STATE OF NORTH CAROLINA  
DEPARTMENT OF TRANSPORTATION

November 9, 2012

Subject: **Response to US Army Corps of Engineers Letter** for the proposed NC 133 Connector from NC 211-133 (Southport Supply Road) to NC 87-133 (River Road), Brunswick County, TIP R-3324.

# **SKewed MULTI-BARREL LOW FLOW CHANNEL,SILLS AND FLOOD PLAIN**

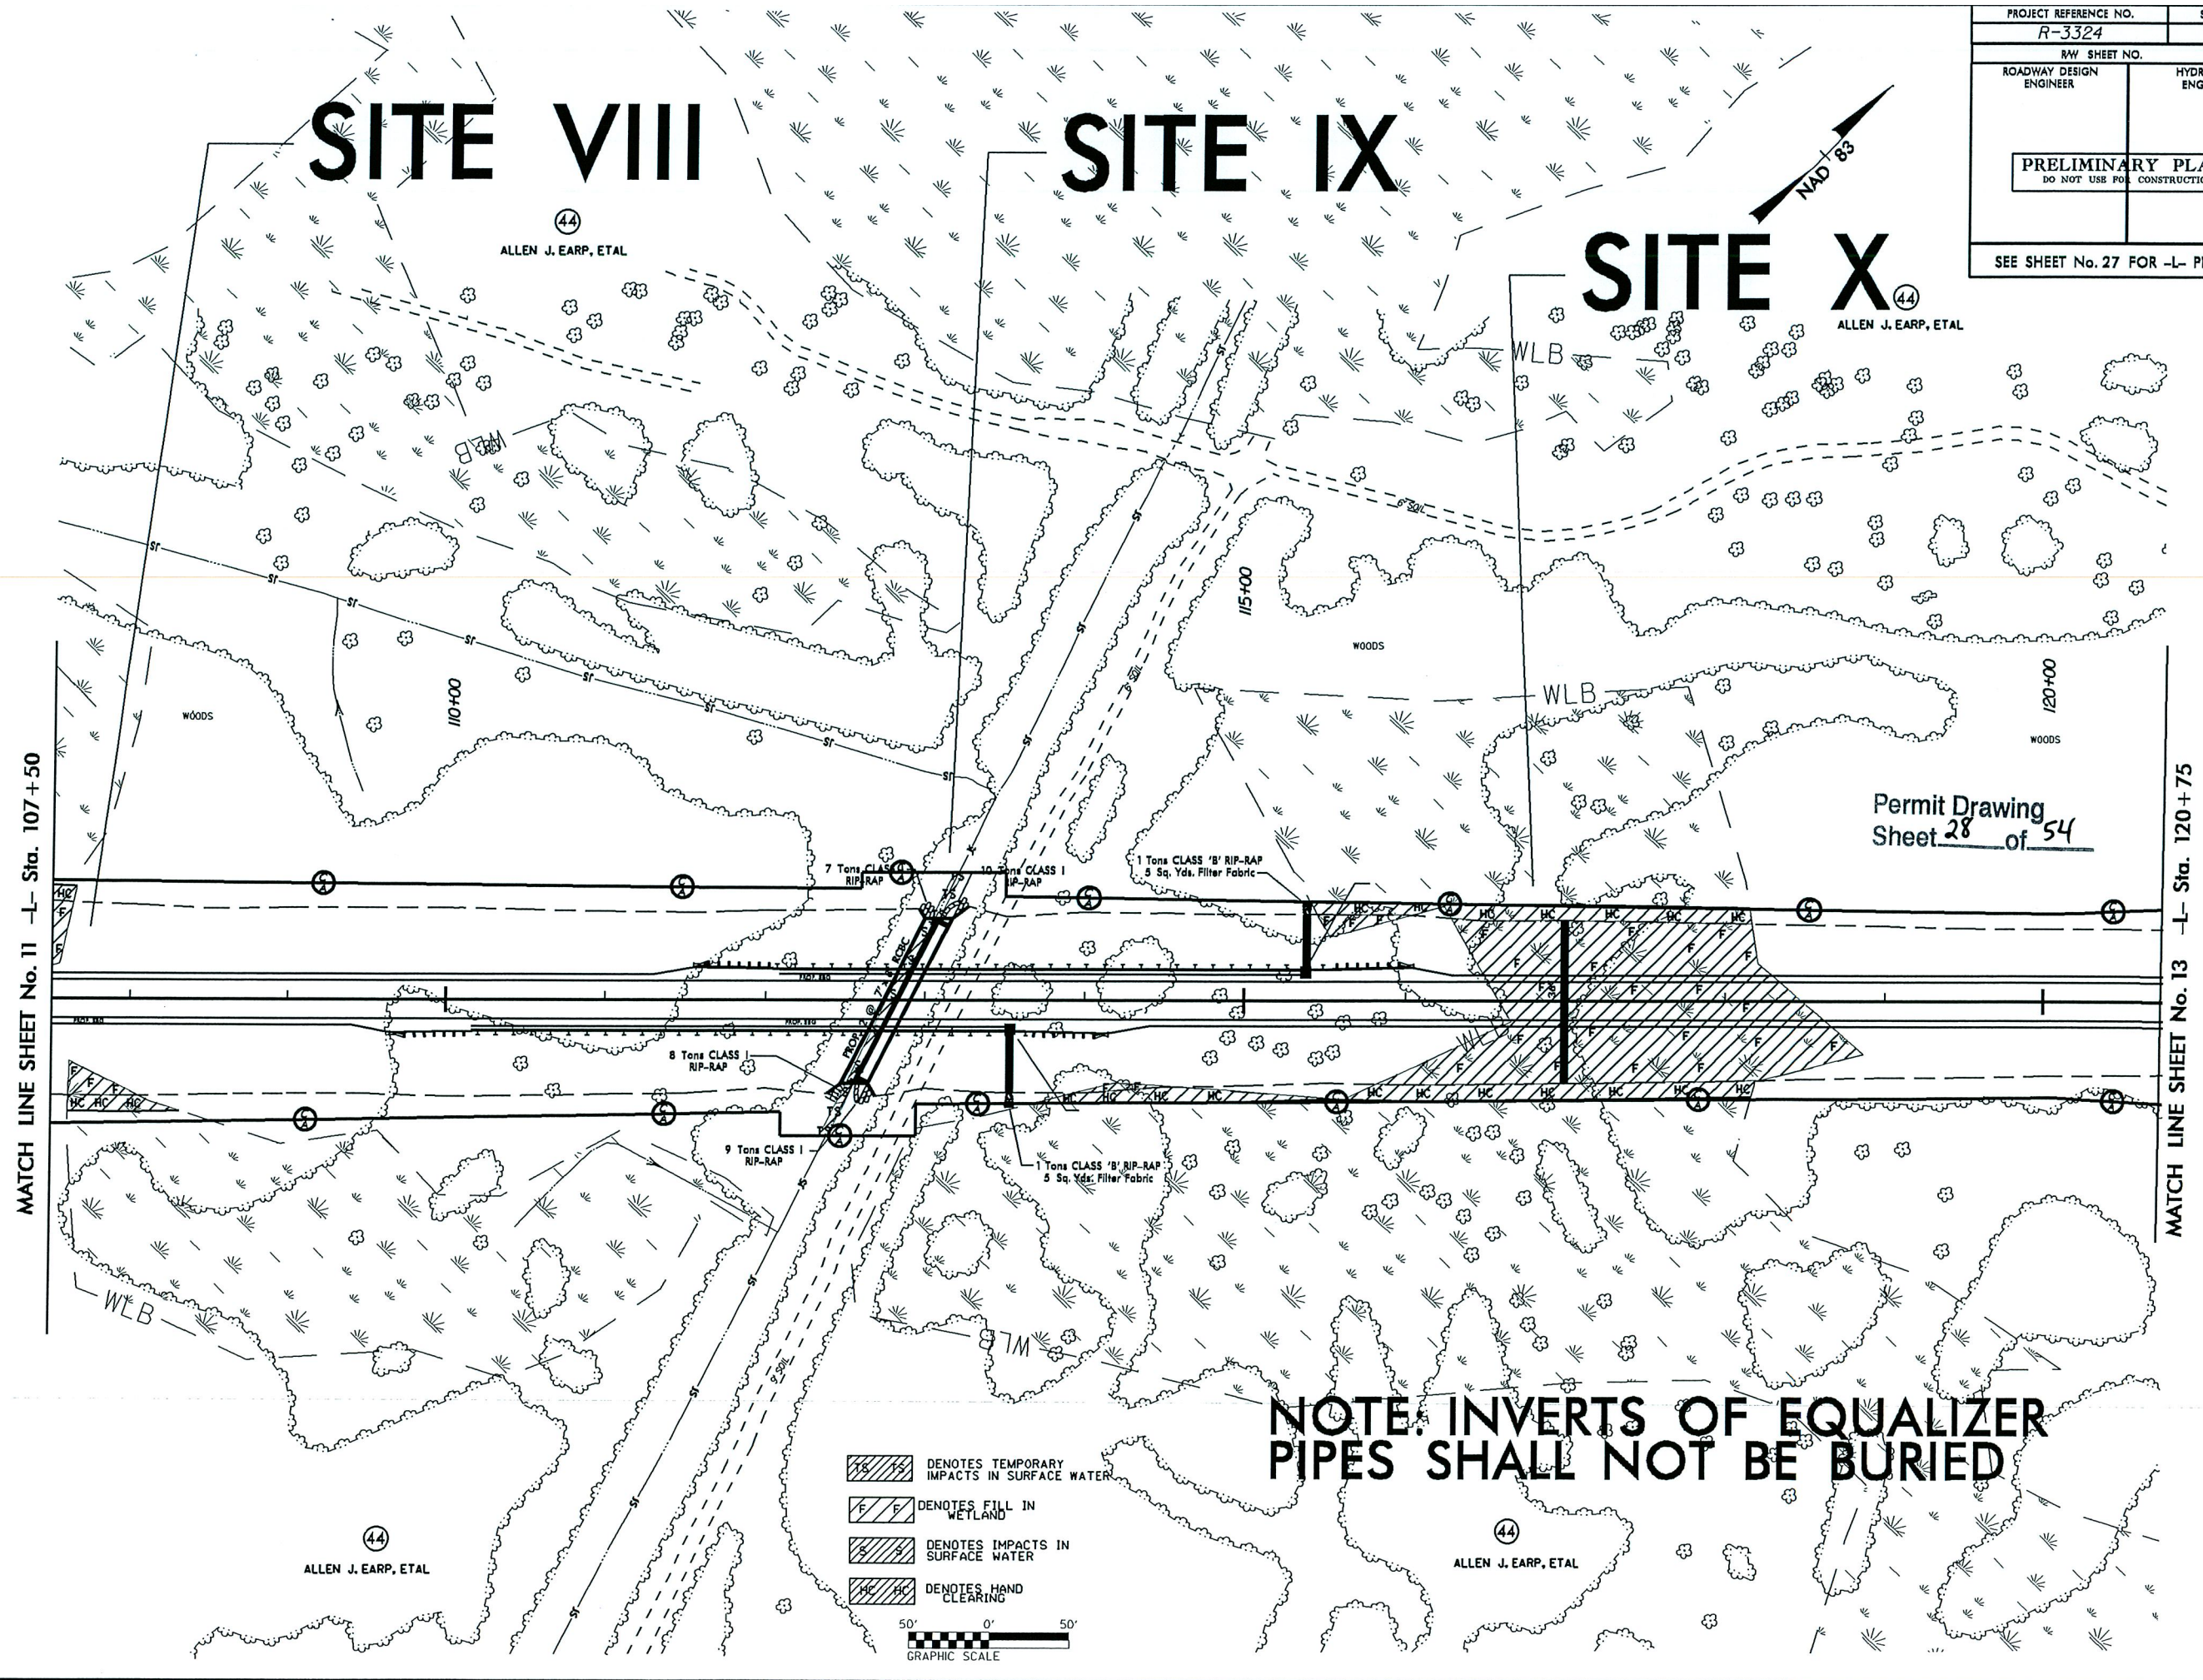
9. Site 11: *Existing channel is approximately as wide as current 48" structure, yet new structure proposed is 9'. What is being implemented to maintain the low flow channel at this proposed crossing?*

A detail showing the sill layout for the culvert has been added to the permit drawings. The low flow conditions are being maintained.

# LOW FLOW CHANNEL AND SILLS

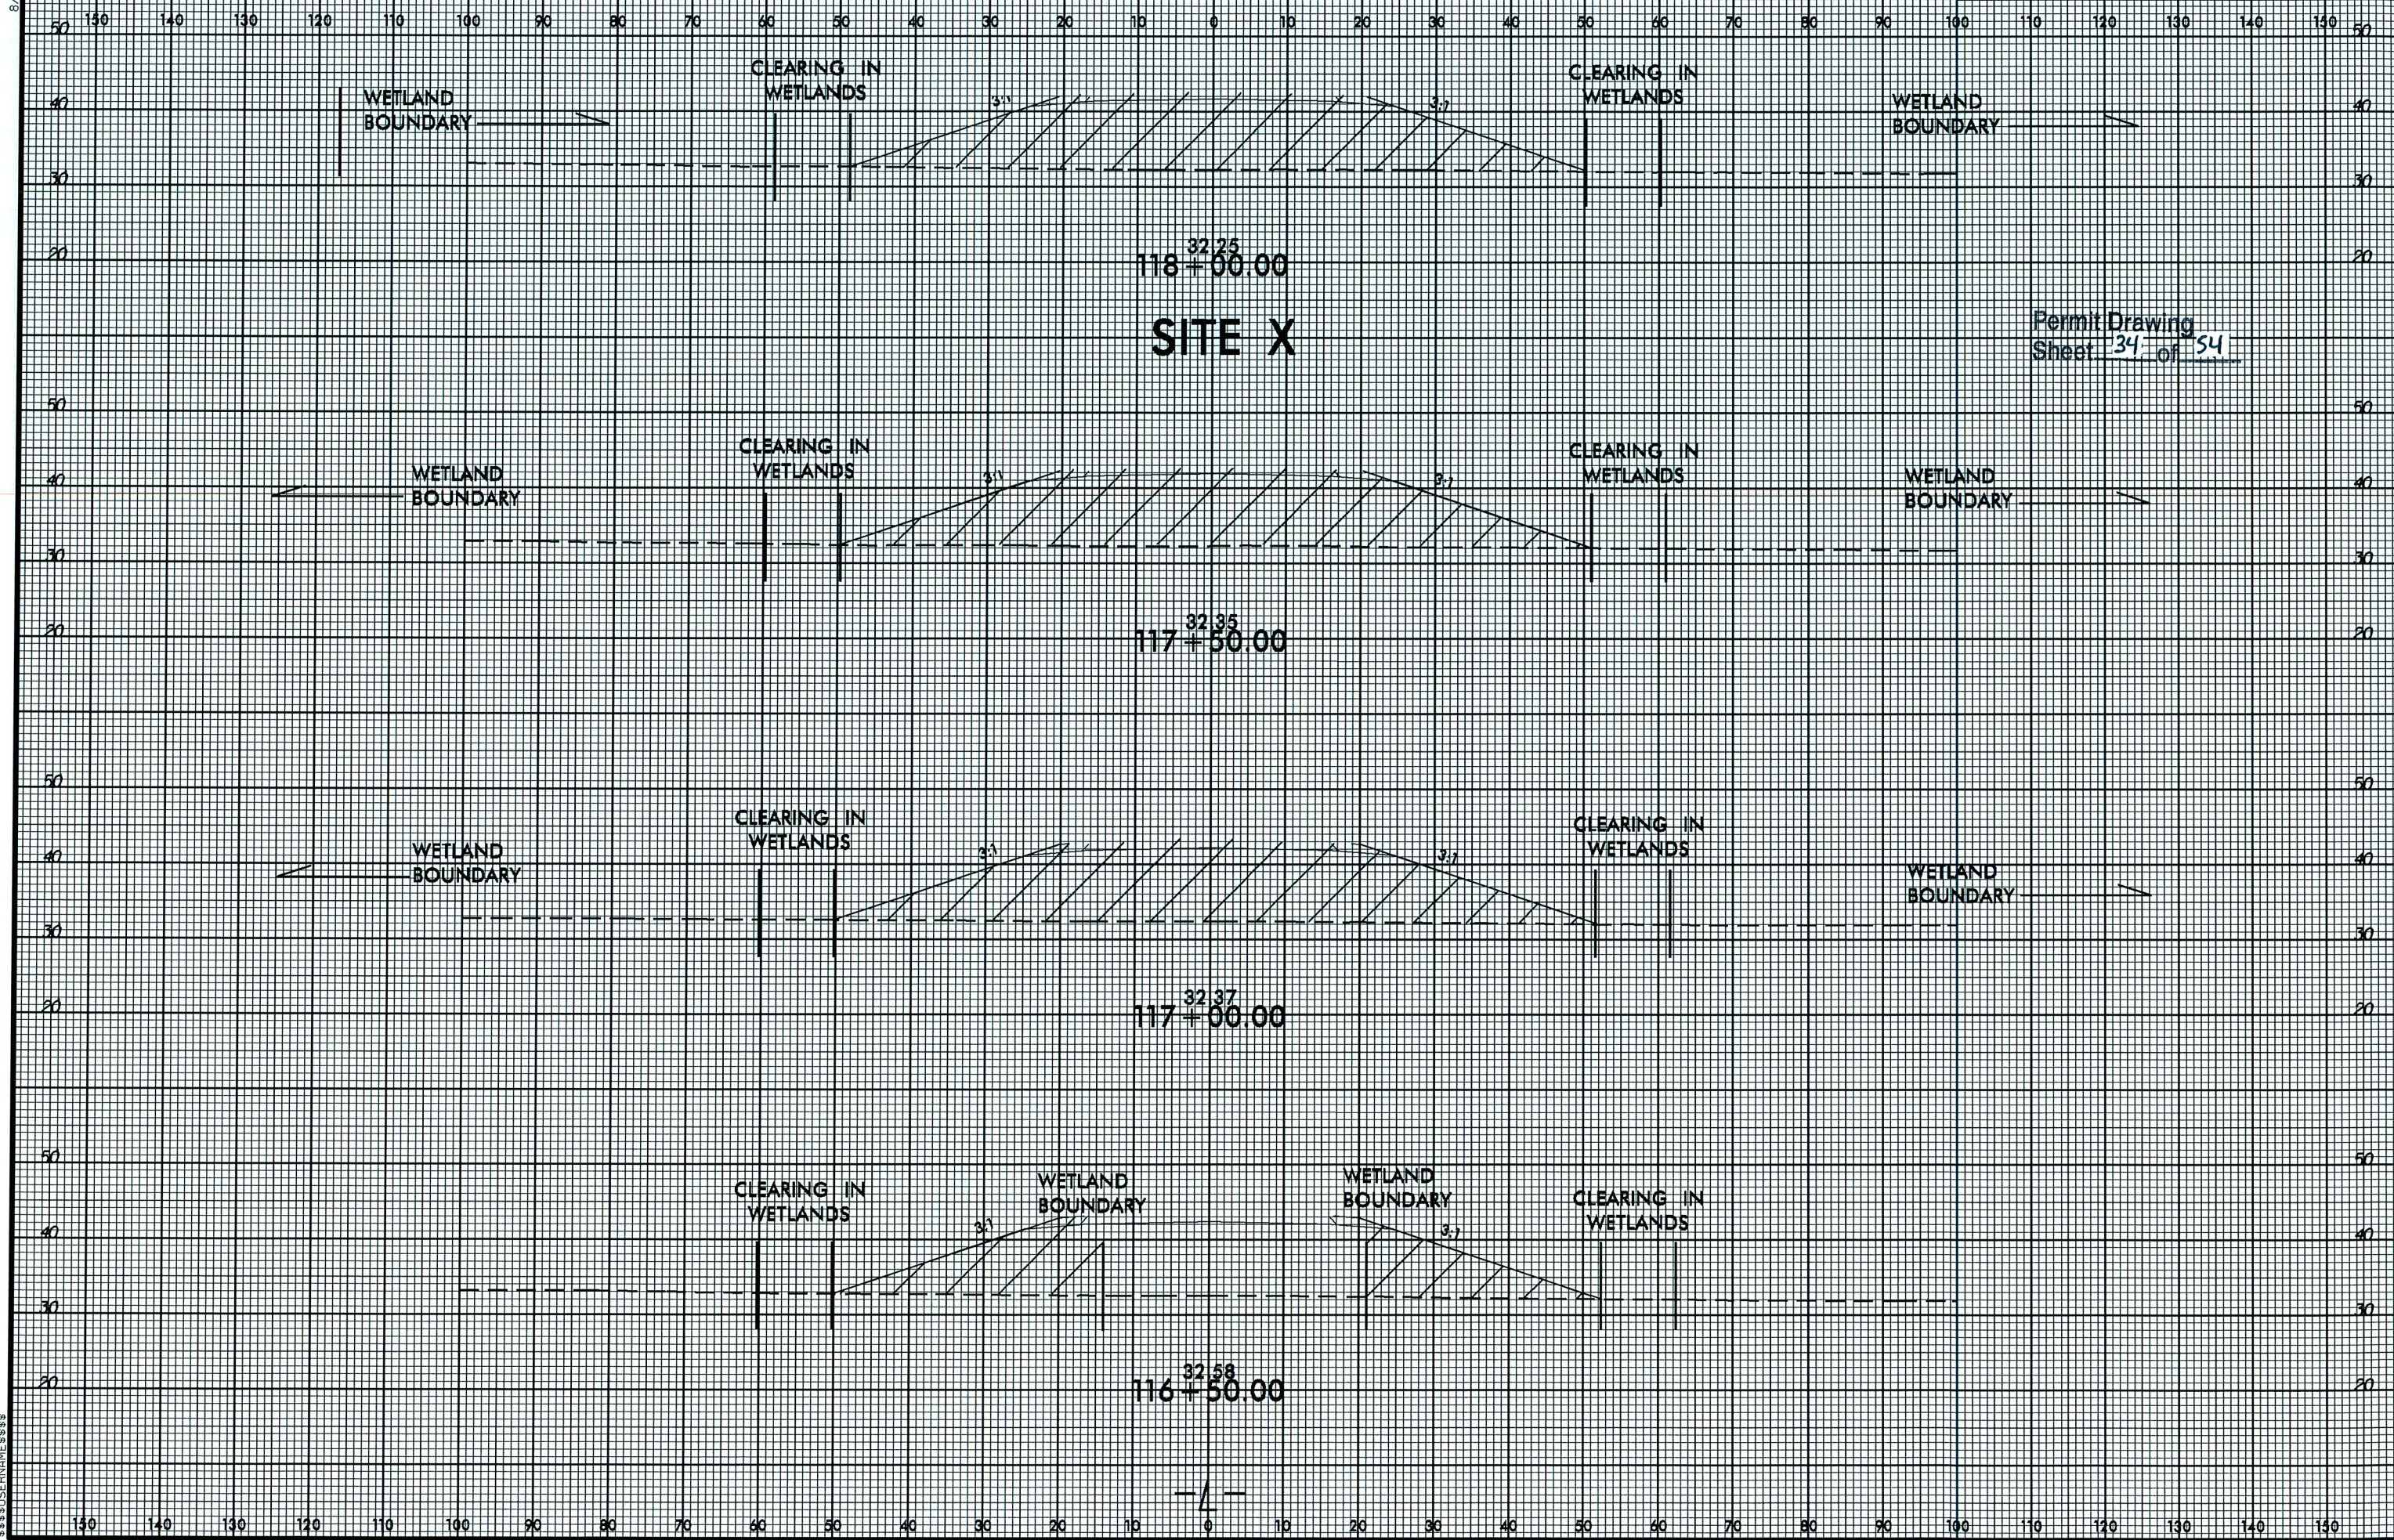
8. Site 9: *Are there cross sections of the sill to maintain low flow conditions in the current submittal?*

A detail showing the sill layout for the culvert has been added to the permit drawings. The low flow conditions are being maintained.
